Our Case Number: ABP-314724-22

Date: 29 November 2022

Re: Railway (Metrolink - Estuary to Charlemont via Dublin Airport) Order [2022]
Metrolink. Estuary through Swords, Dublin Airport, Ballymun, Glasnevin and City Centre to
Charlemont, Co. Dublin

PUMPING STATION - PLAN

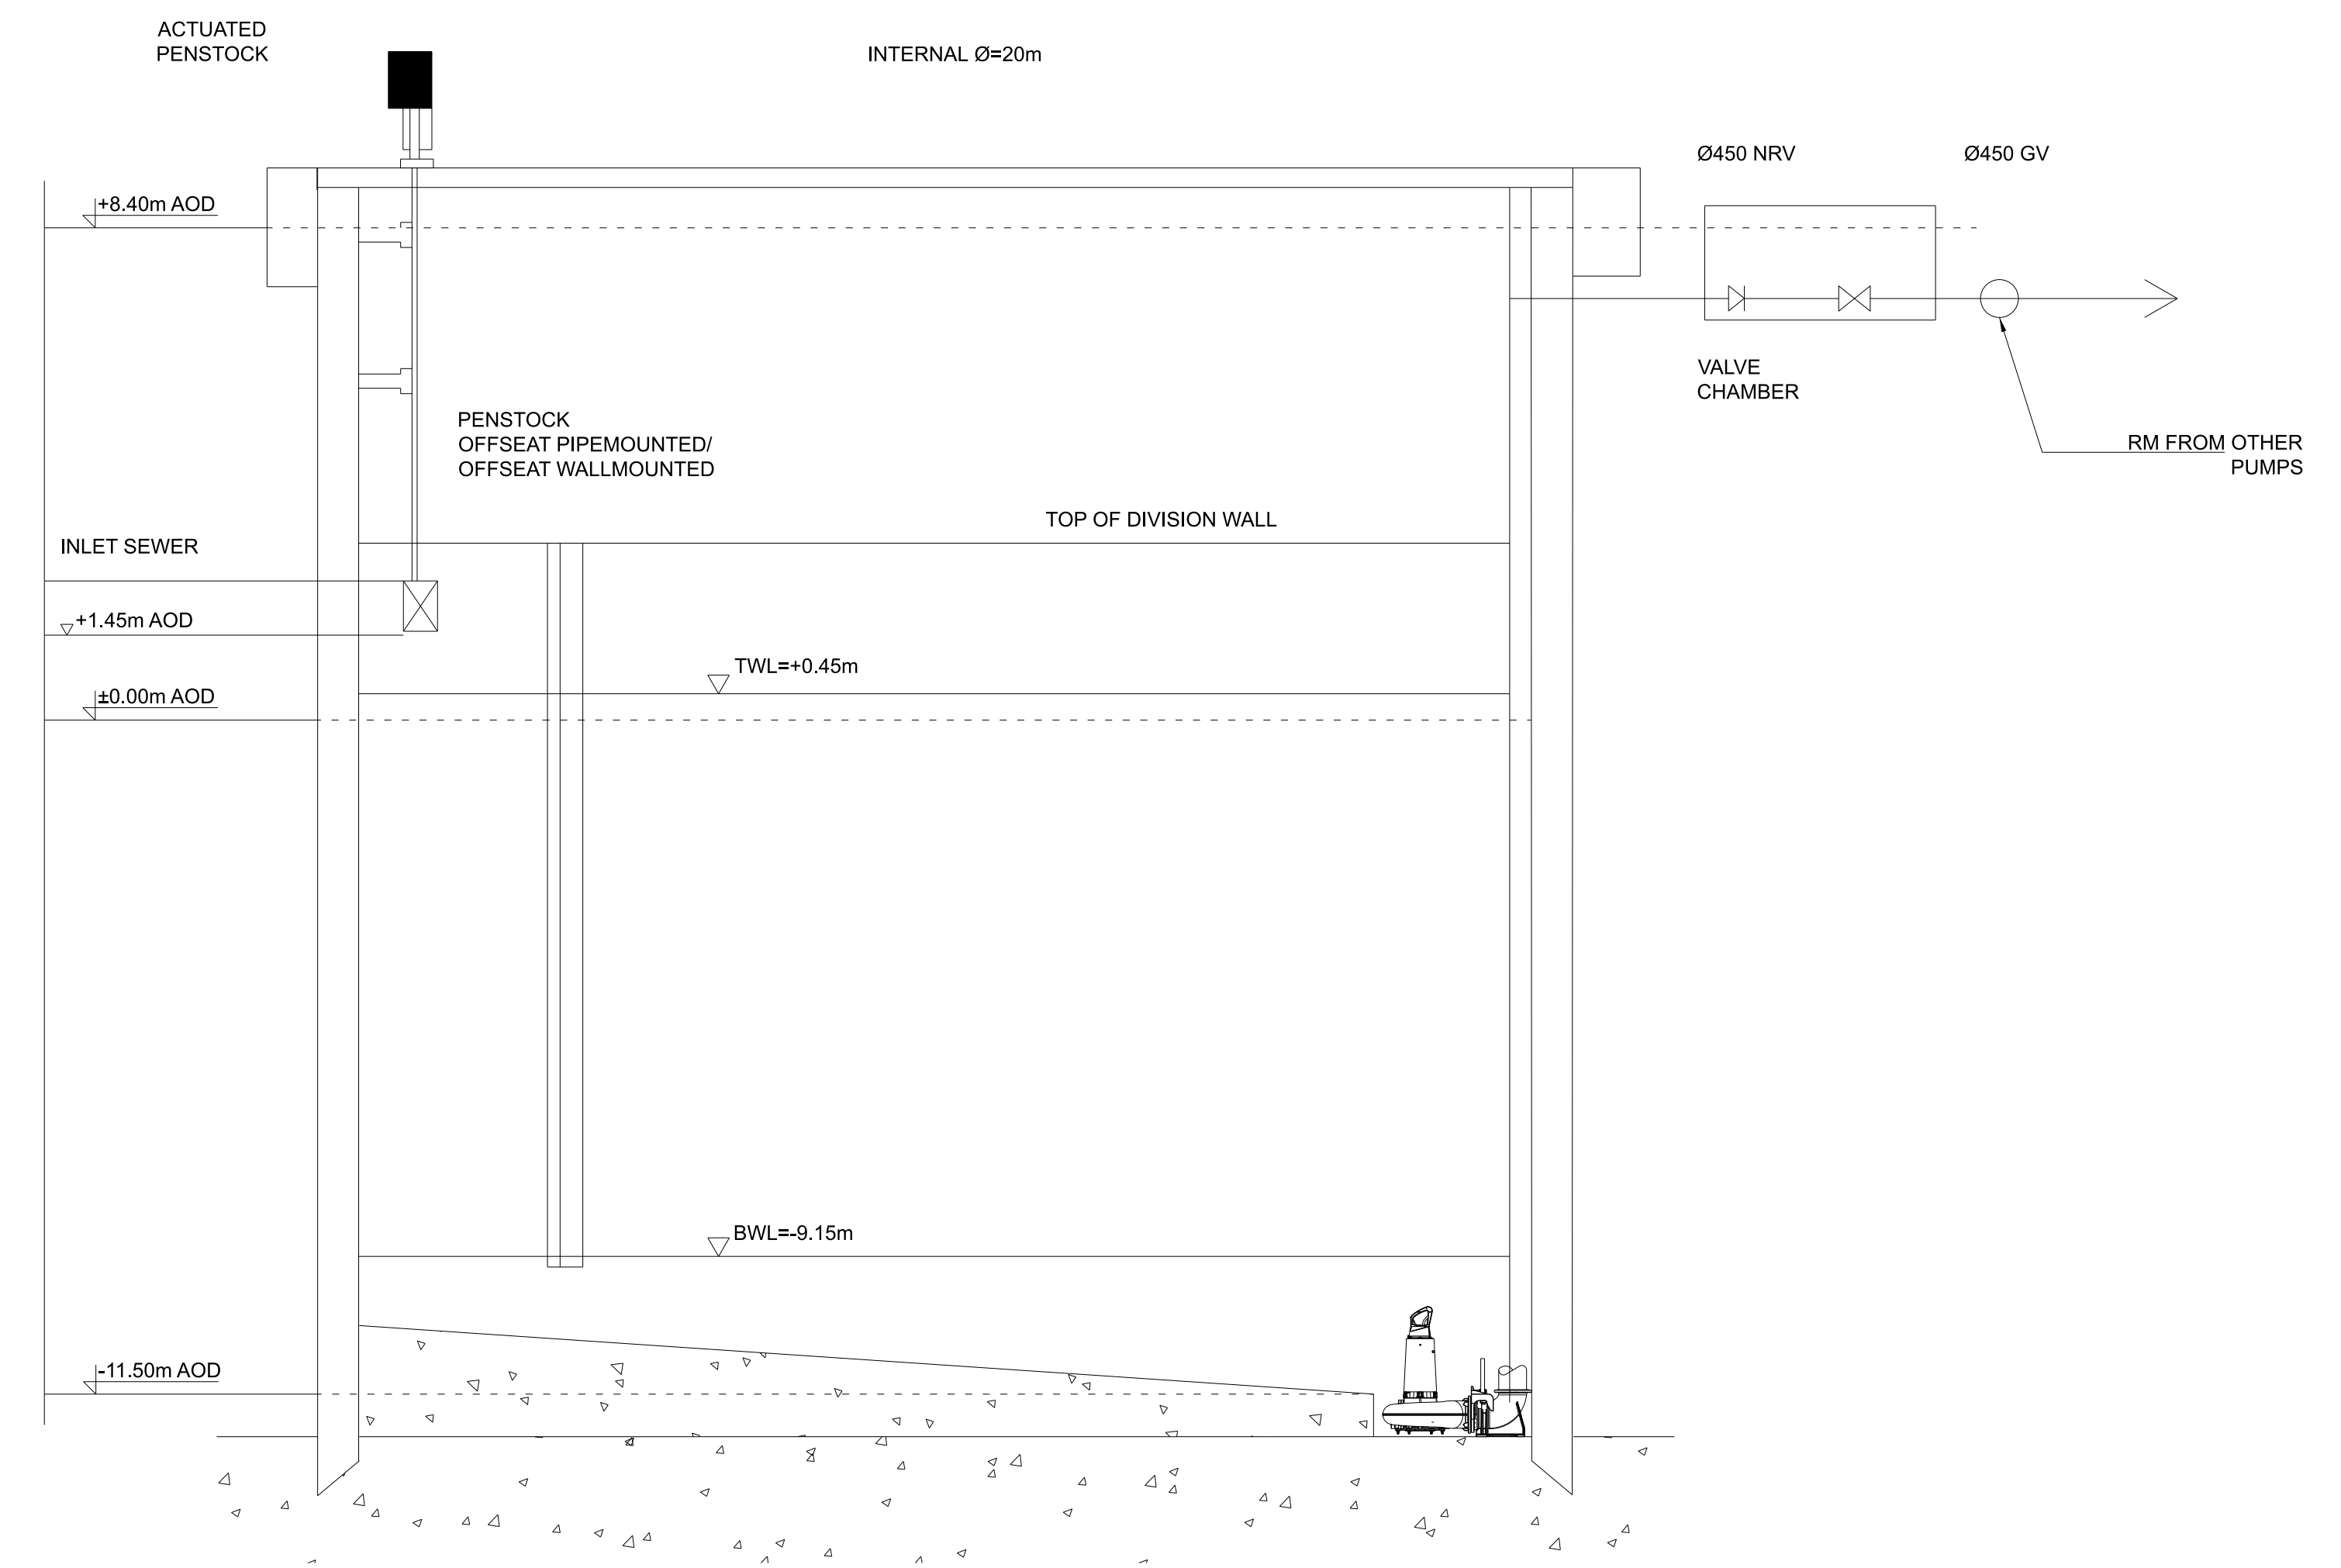
Now this new linear park sits between a dual carriageway, an exposed section of the metro line and a new planned pumping station. The new zig zag path from the proposed Estuary junction to North street offers the same access as exists currently (and in the proposed new layout) along the pedestrian path by the side of North street. At the other end, it only serves as a shortcut between Estuary Court and North street via Seatown Villas. Something that is not required as there is direct access from Estuary court via the pedestrian bridge over the Seatown roundabout on the R132 and will continue in the new proposed R132 Connectivity project where the proposed Seatown Road junction concept has both pedestrian and cycling crossings provided at all sides of the junction for easy crossing to either side of Seatown road or south along the R132 which would be the intended direction of travel for the majority of crossings at this junction to access the new proposed Seatown Metrolink station (refer to image 4).
